Online Comment

Application H14-1286-25
Location Land off Stephenson Avenue Pinchbeck Spalding PE11 3SW
Proposal Erection of a mixed use commercial site for 11 industrial units & 4 office units

Date Submitted 26-01-26
For/Against Objections

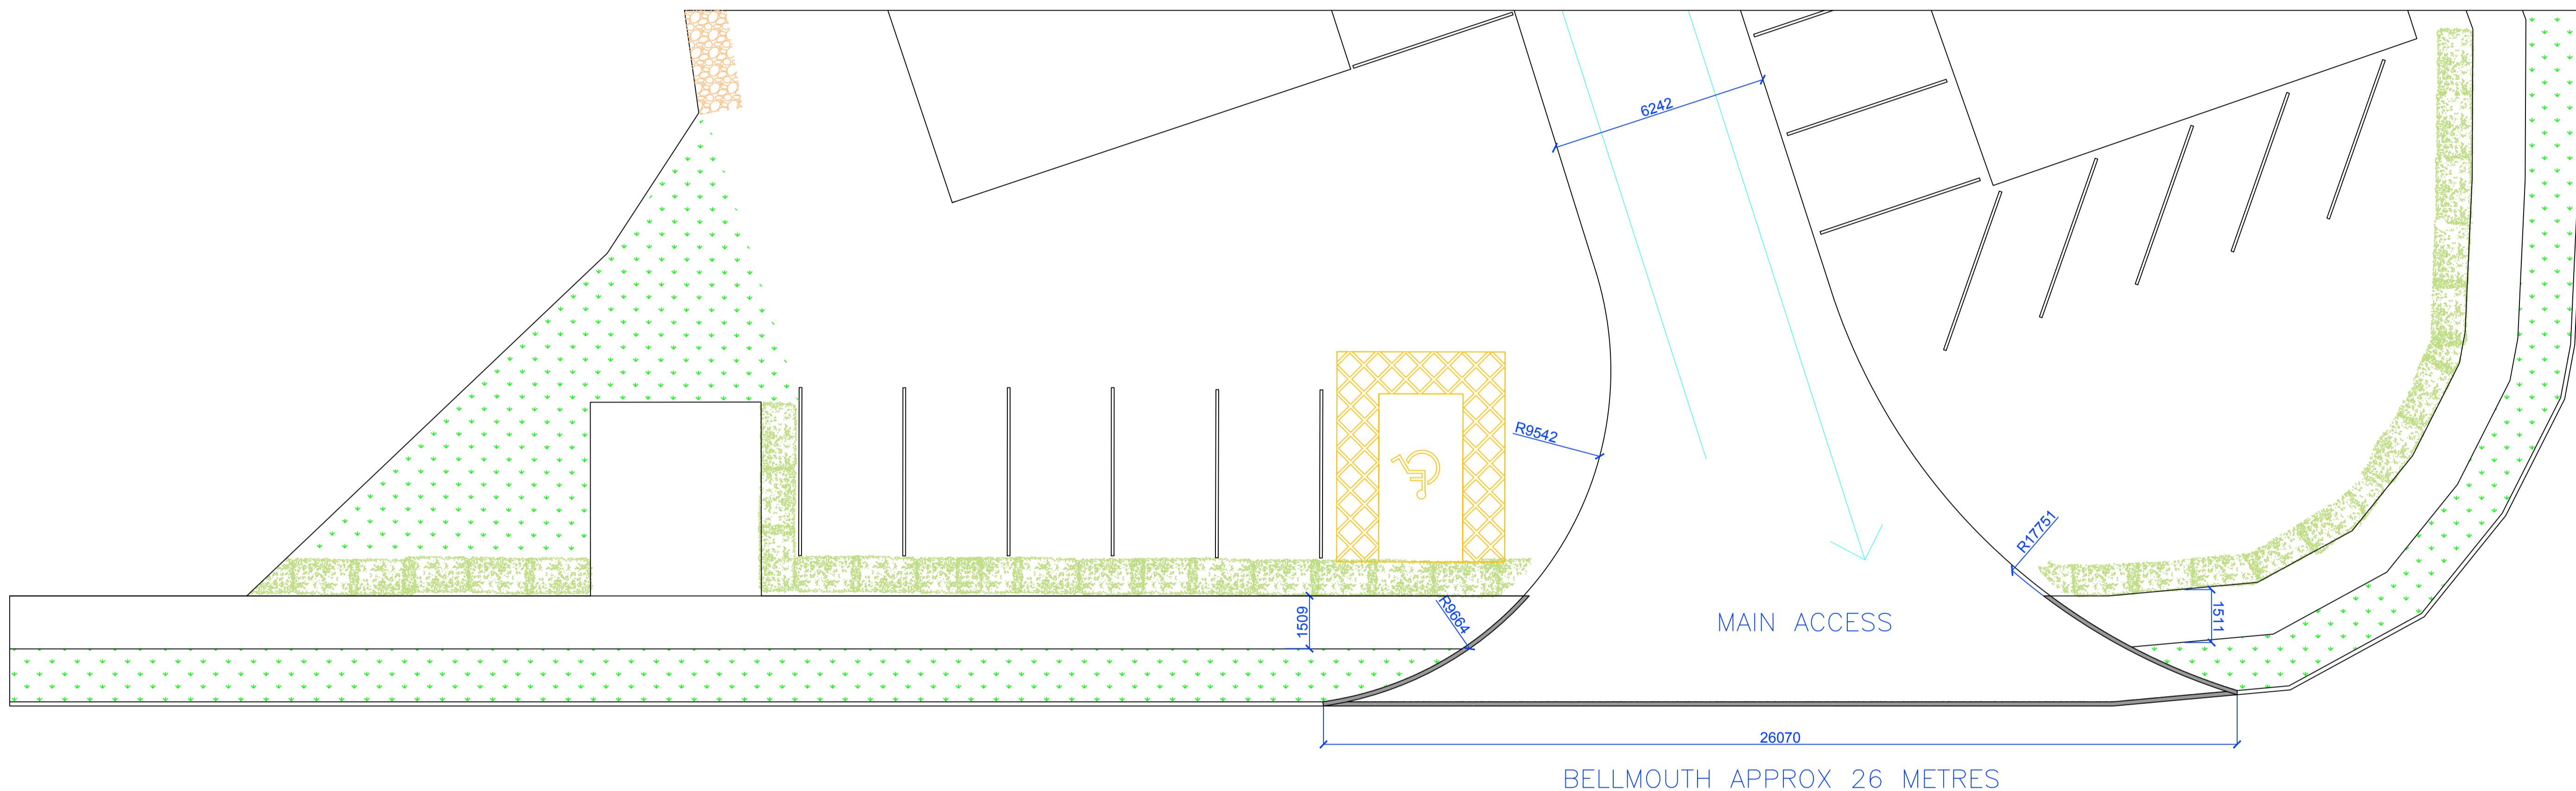
The cycle stands shown on drawing V12.9 obstruct a doorway in an adjacent building. The application form states that parking will be provided for six bicycles, but the drawing shows only five stands. We therefore object to the application in its present form. Please consult Pedals again if the application is modified to show more appropriate provision for cycle storage and parking in accordance with the relevant policy of the Local Plan.
